A1 Birtley to Coal House
Scheme Number: TR010031

Applicant's Response to ExA's Third Written
Questions

Rule Number:	Rule 8(1)(b)
Planning Inspectorate Scheme Reference	TR010031
Application Document Reference	Applicant's Response to ExA's Third Written Questions
Author:	A1 Birtley to Coal House Project Team, Highways England

Version	Date	Status of Version
Rev 0	9 June 2020	For Issue

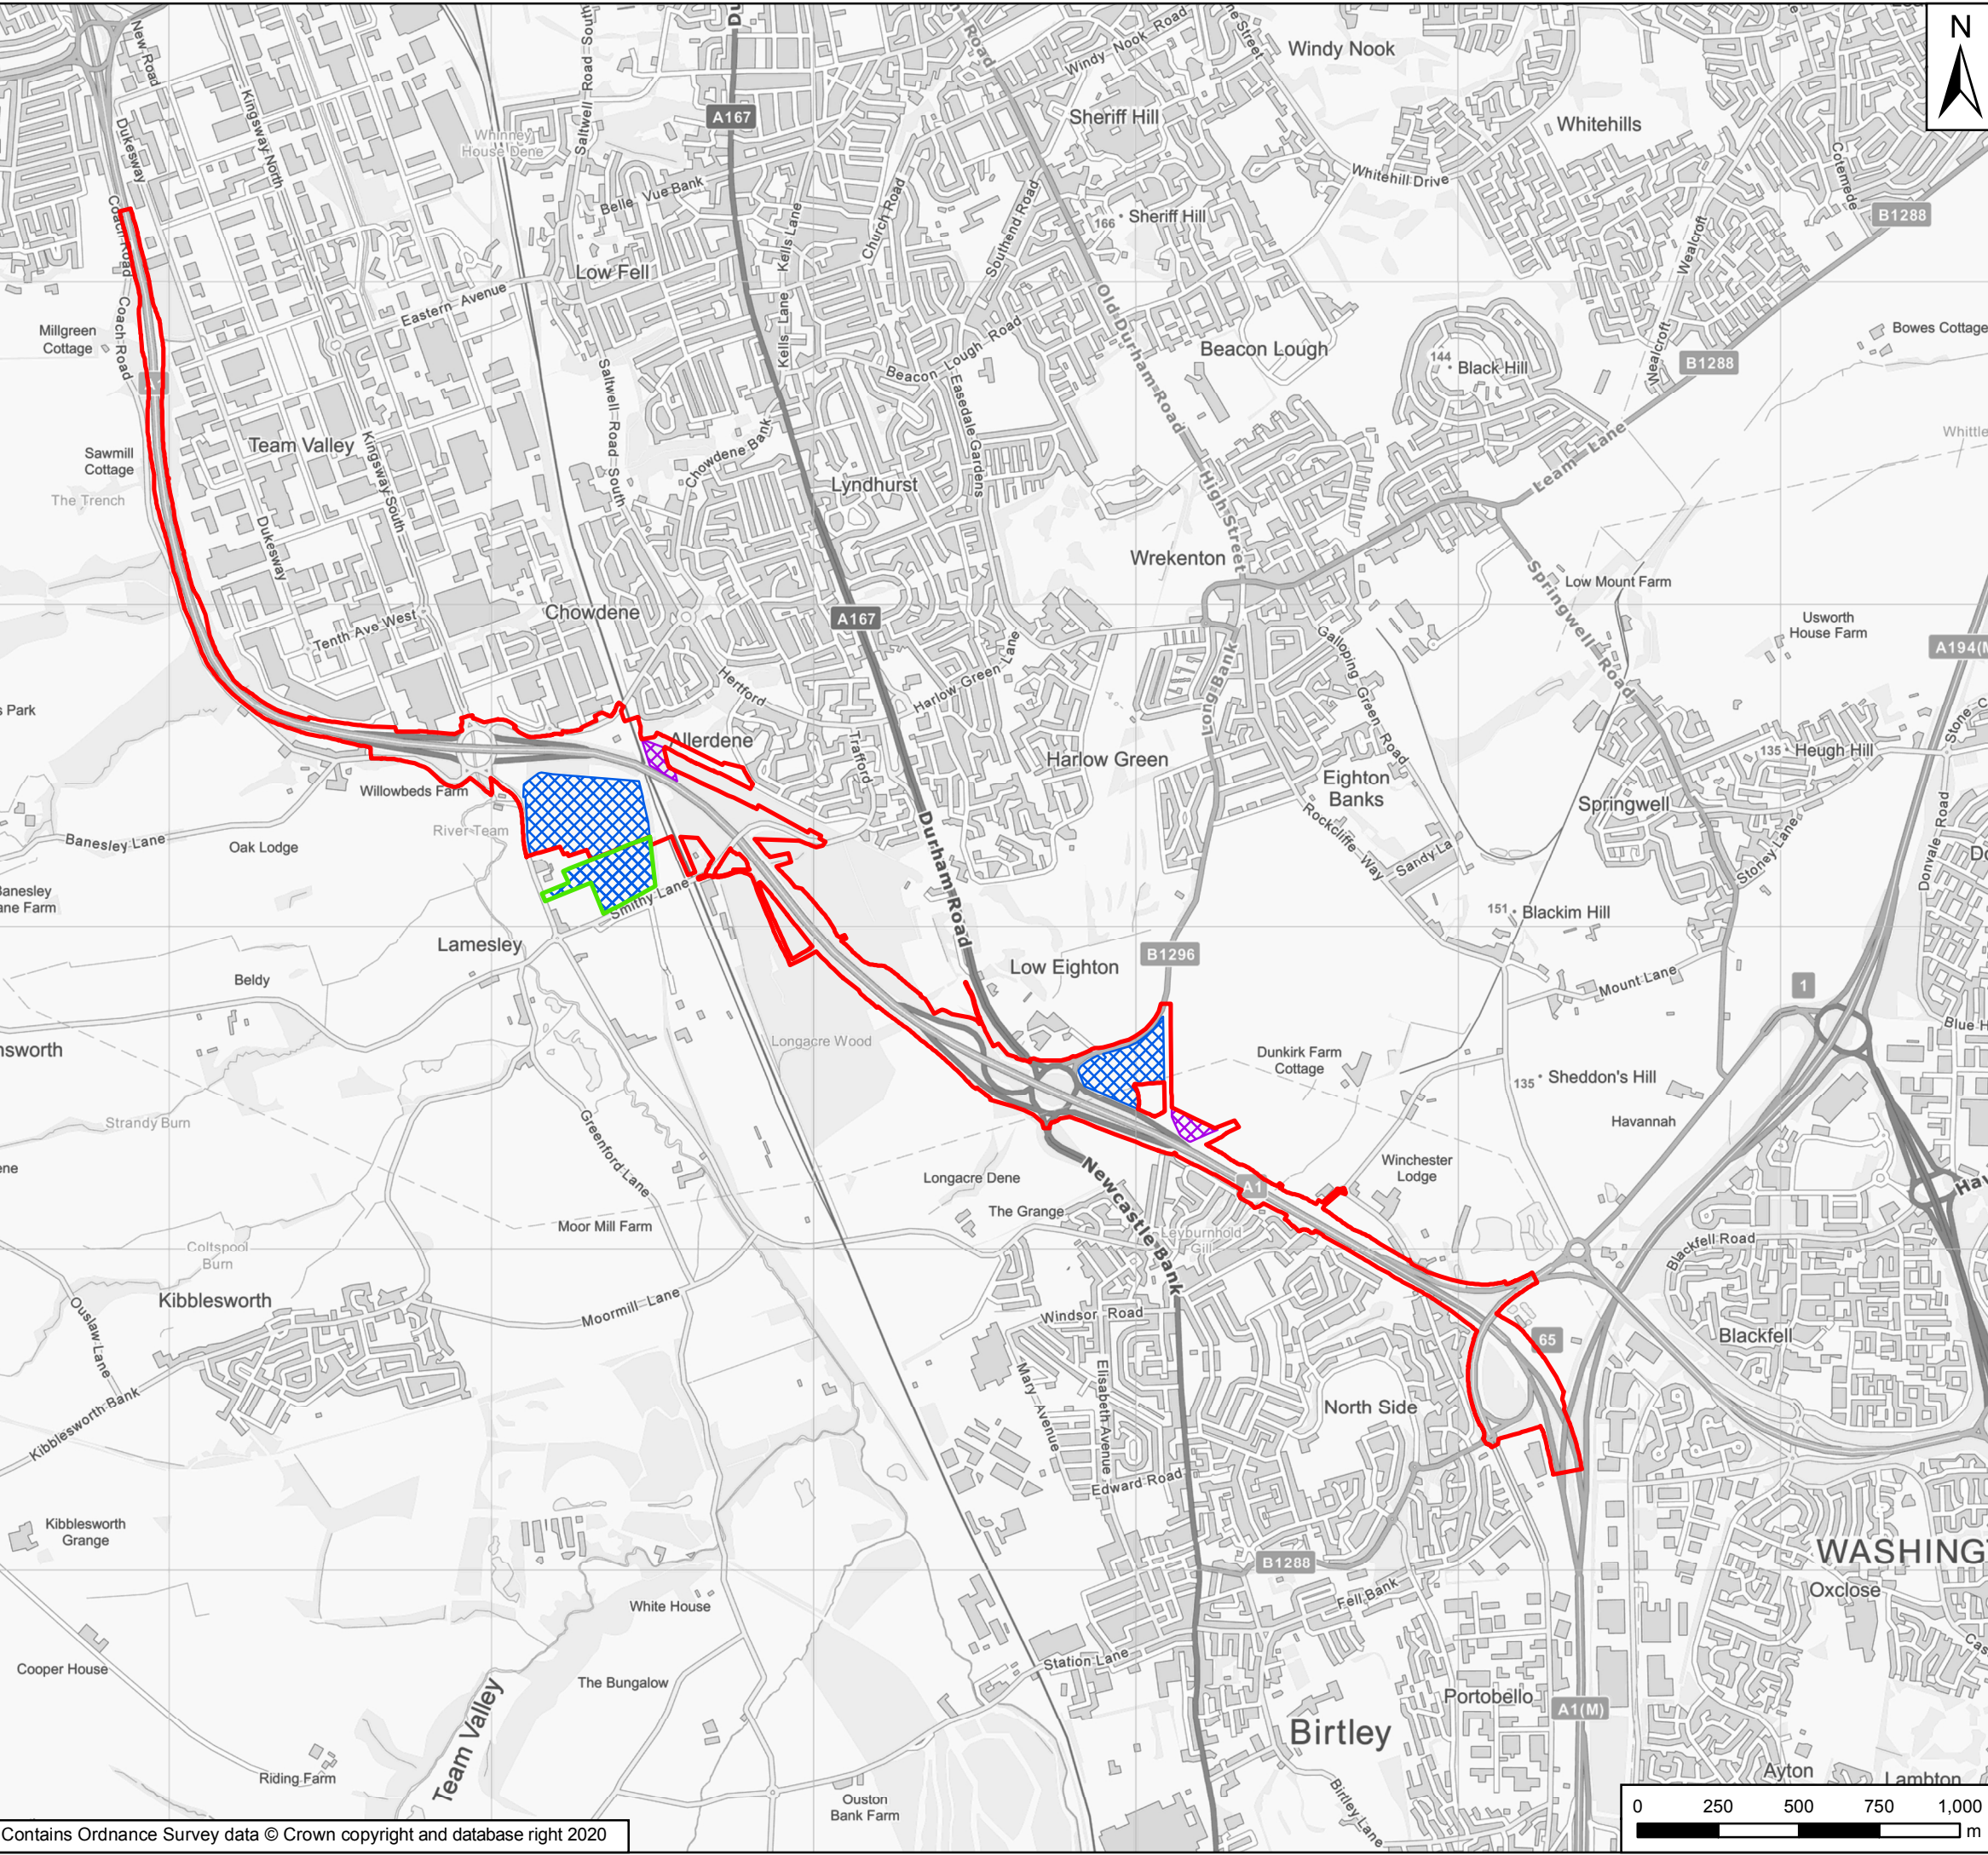
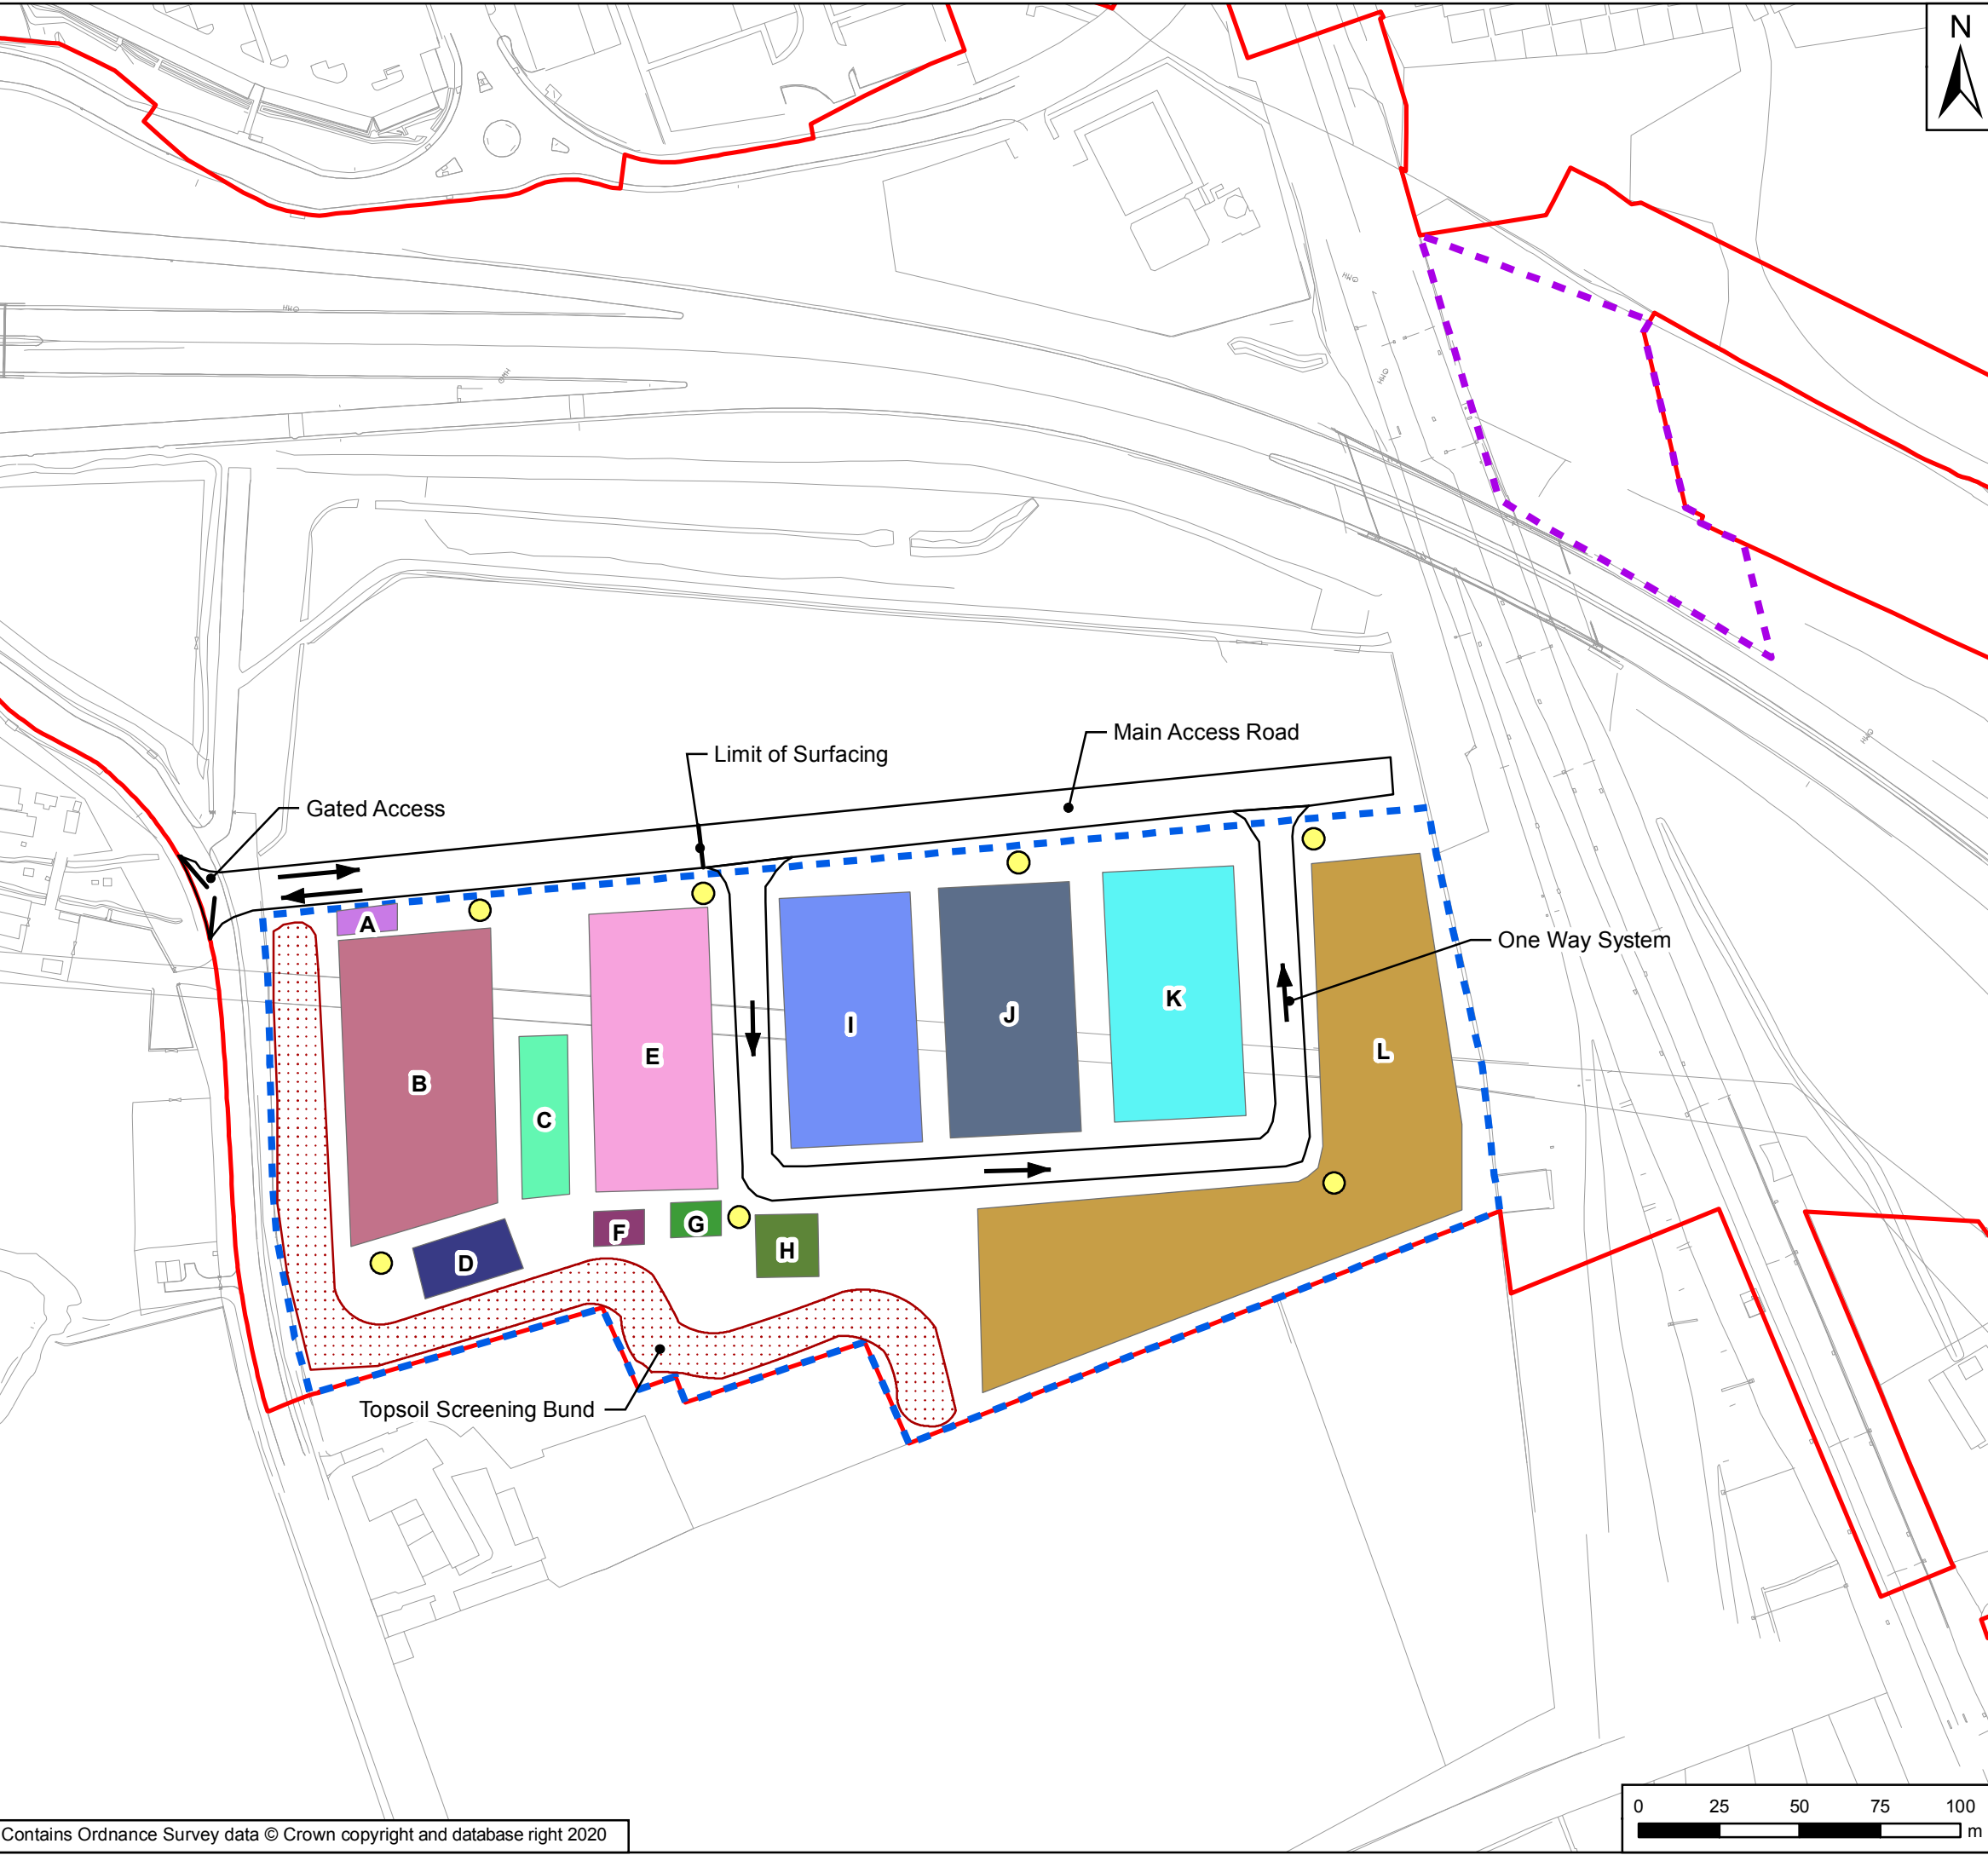
3.0.2	The Applicant	<p>Appendix A (site compounds) of the latest version of the outline CEMP [REP6-08] does not include the additional land to be used for material stockpiling.</p> <p>a) Can the Applicant include this additional land in the outline CEMP?</p>	<p>The new version of Appendix A - Figure 1 Site Compound Plan of the Outline CEMP [REP6-08 and 19] has been prepared that has been updated to include the additional land to be used for material stockpiling. This has been submitted as a new figure within Figure 1/AL, namely "Site Compound Plan Detailed View, Junction 67 (Additional Land)". This is contained within Figure 1/AL Site Compound Plan in Appendix A of the Outline CEMP [REP6-08 and 19], an updated version of which has been submitted as part of Deadline 8 (09 June 2020).</p> <p>In order to address the circumstances where the Secretary of State decides to grant compulsory powers over plot 3/13a, which is the additional land, the Outline CEMP [REP6-08 and 19], an updated version of which was submitted as part of Deadline 8 (09 June 2020), has been amended to provide that:</p> <p><i>"The final proposed layout of the construction compounds to be sited at Junction 67 and Eighton Lodge will be included in the CEMP and must be in substantial accordance with Appendix A - Figure 1/AL Site Compound Plan of the Outline CEMP. Where parcel 3/13a is included in the powers granted by the made DCO, the layout of the construction compound to be sited at Junction 67 shall be in substantial accordance with the image in Figure 1/AL Site Compound Plan Detailed View, Junction 67 (Additional Land)".</i></p>
